Mr. Chris Weiss
CTS, Inc.
1100 Alvarado, NE Suite A
Albuquerque, New Mexico 87110
RE
RE: GRADING & DRAINAGE PLAN FOR BUSINESSLAND STORE
(H18-D31) RECEIVED MARCH 13, 1984

REF: GRADING AND DRAINAGE PLAN FOR BUSINESSLAND STORE (H18-D31) RECEIVED
APRIL 10, 1984

DRAINAGE / GRADING PLAN
BUSINESSLAND STORE
Menaul and Indiana

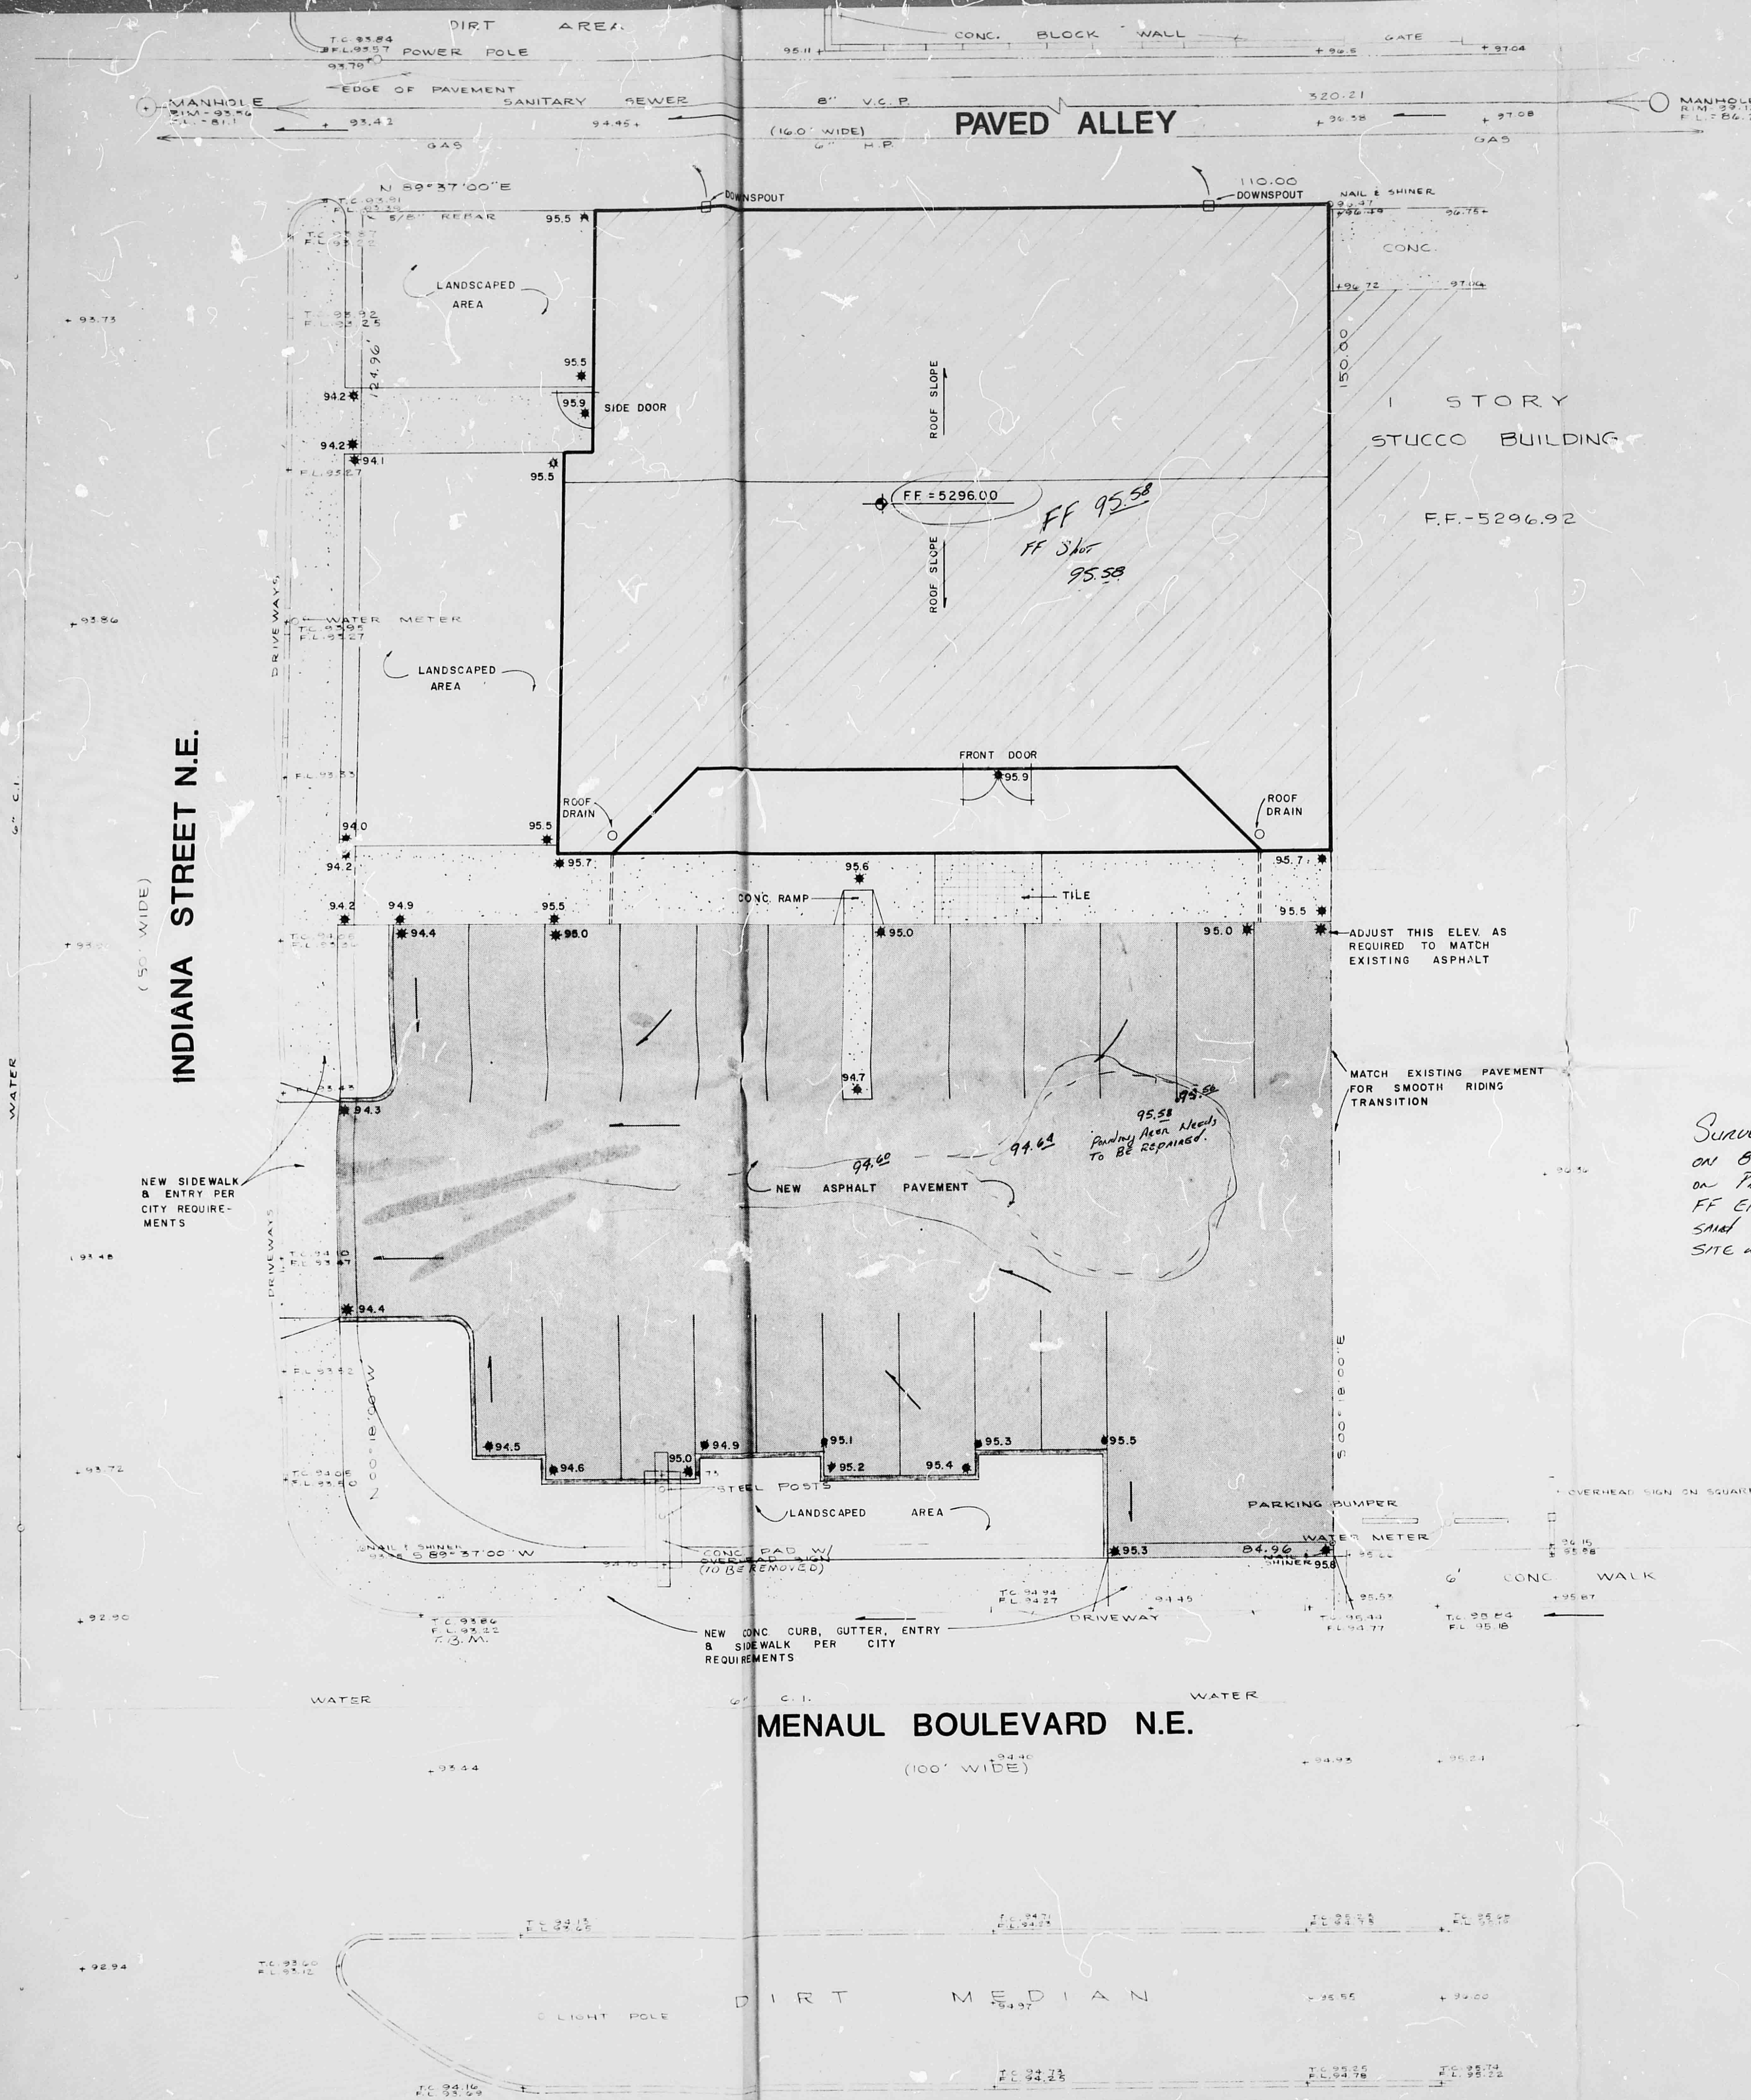
1. I realize that it was established in the pre-design meeting that free discharge is allowed however, drainage analysis, per the DPM, is still required.
2. Please utilize the new information sheet that you were provided for future submittals.
